08149
27 April 2010

**MODIFICATION TO MAJOR PROJECT 08-0093
DARLING WALK – PUBLIC DOMAIN**

We refer to the abovementioned Project Application for public domain works at Darling Walk, Darling Harbour.

AD903906-01

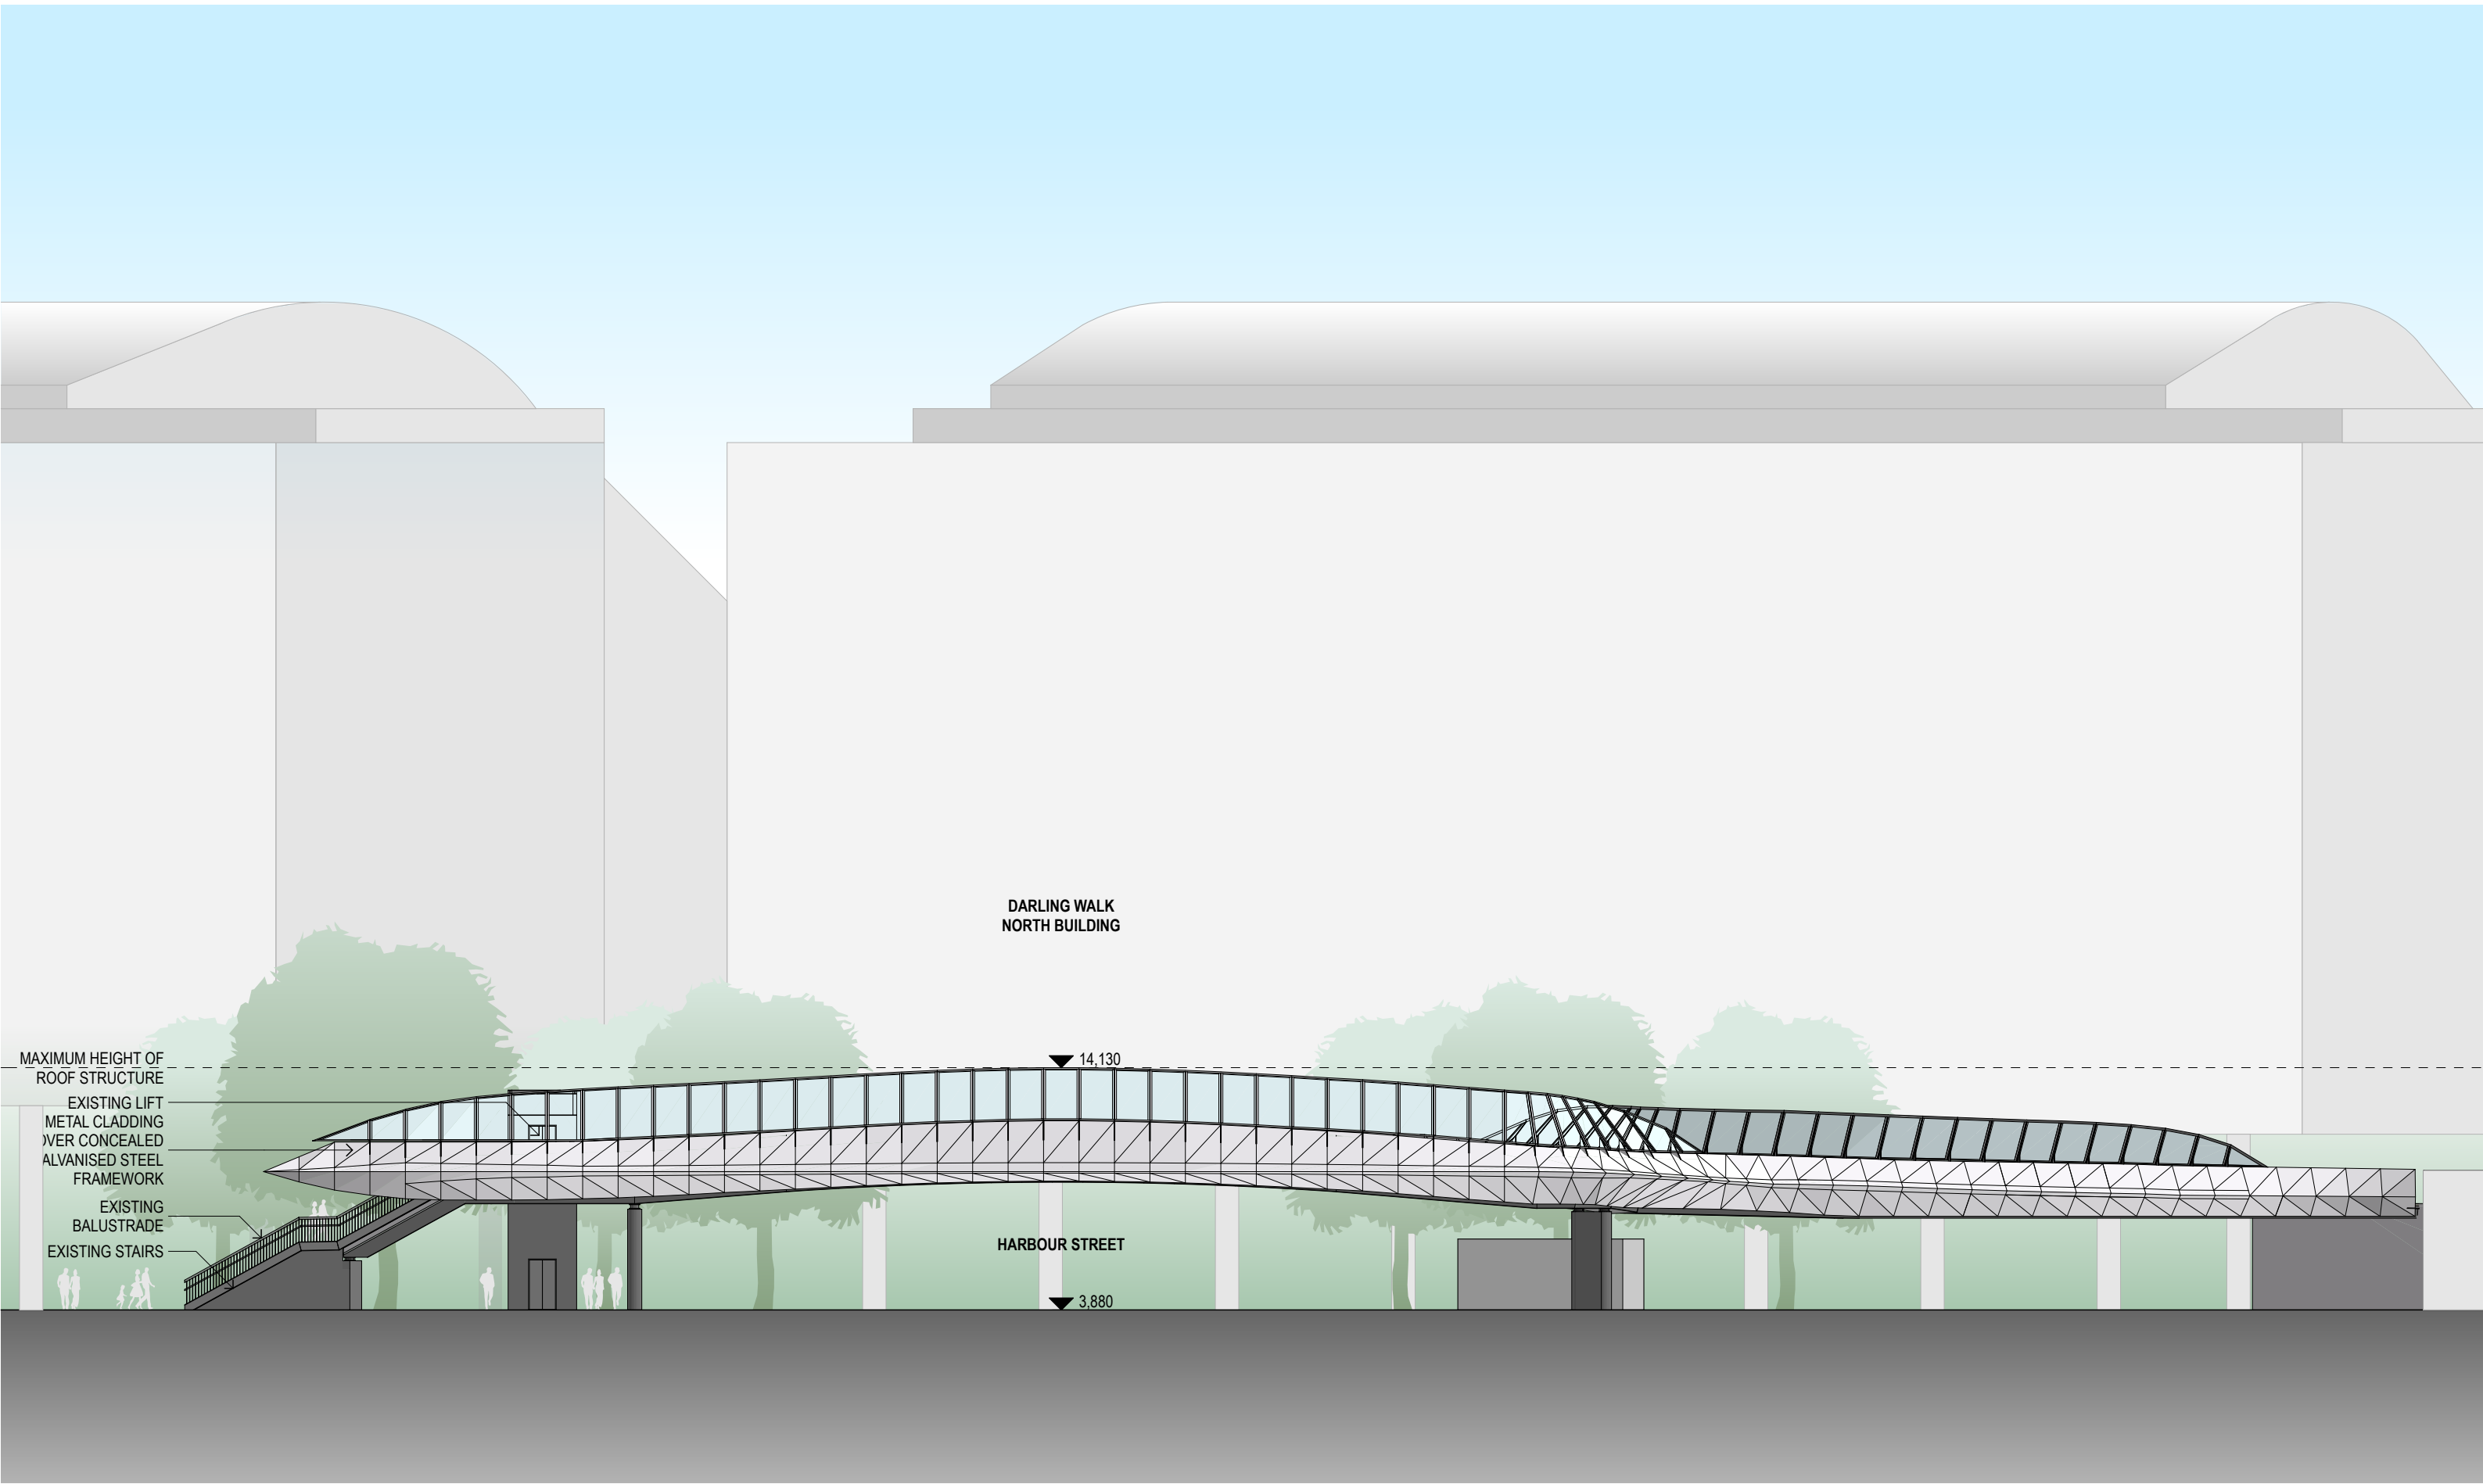
The proposed extension to the canopy over the stairs at the eastern end of the footbridge is to provide additional weather protection and to help create a more clearly defined entry to the precinct.

Drawing No.	Revision	Name of Plan	Date
AD 951008	-	Footbridge — Elevation	July 20 2009
AD 951009	-	Footbridge — Section	July 20 2009
AD903900-03		General Arrangement Plan	22.04.2010
AD903905-01		Typical Section	01.04.2010
AD 903906-01		North Elevation	01.04.2010
AD 903907-00		Perspectives	01.04.2010

1 GENERAL ARRANGEMENT PLAN
1:250

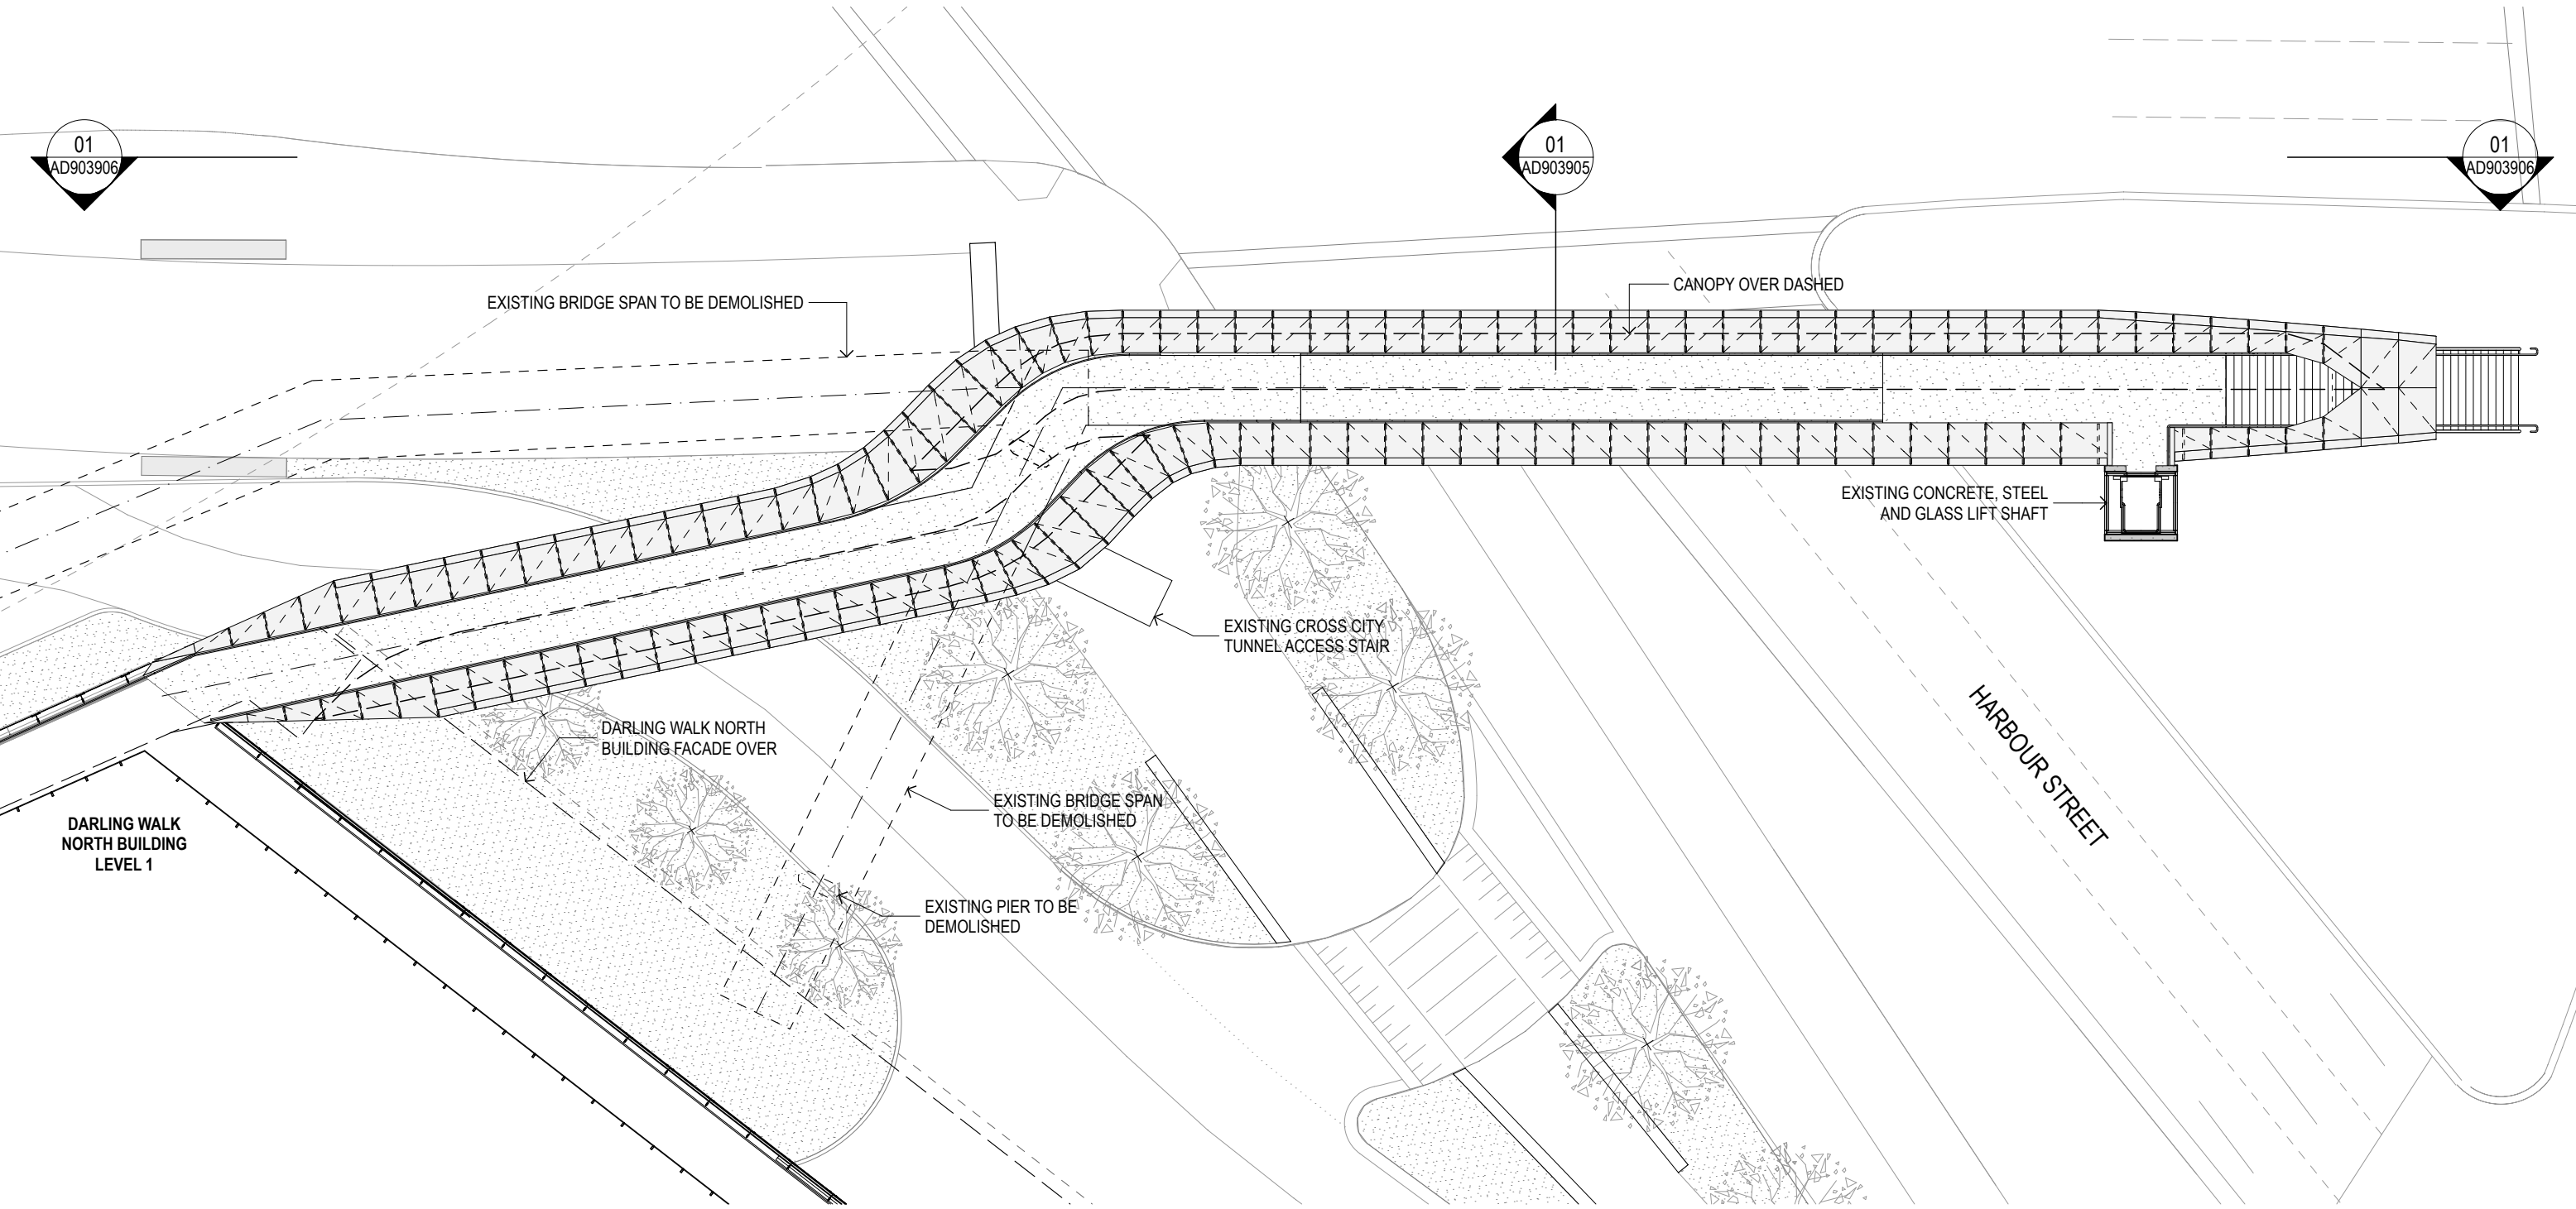
It is proposed to modify the alignment of a section of the Harbour Street footbridge which connects to the northern building. The current design includes a bulged area between the western side of Harbour Street and the new northern building. The proposed new alignment removes the bulged area due to structure engineering requirements. In addition, it is also proposed to extend the canopy over the stairs at the eastern end of the footbridge. The proposed changes are illustrated on the attached drawing – Comparison Plan AD 903908-01.

The approved design of the footbridge included a bulged area to compensate for demolition of a span that previously connected to the old Sega World building, which provided some structural support. The bulged area required additional concrete weighting to balance and stabilise the

bridge. The concrete weighting resulted in a 22% increase in the load on Pier 2 of the bridge. Pier 2 sits above the Cross City Tunnel (CCT) structure.

Since approval of the footbridge design, the operators of CCT have advised that no additional loads could be applied to the footbridge Piers 2 or 3 which are above the CCT structure. Therefore a revised design and alignment of the footbridge is required. Lend Lease have advised that the revised design does not result in any additional loading on Piers 2 or 3 of the footbridge.
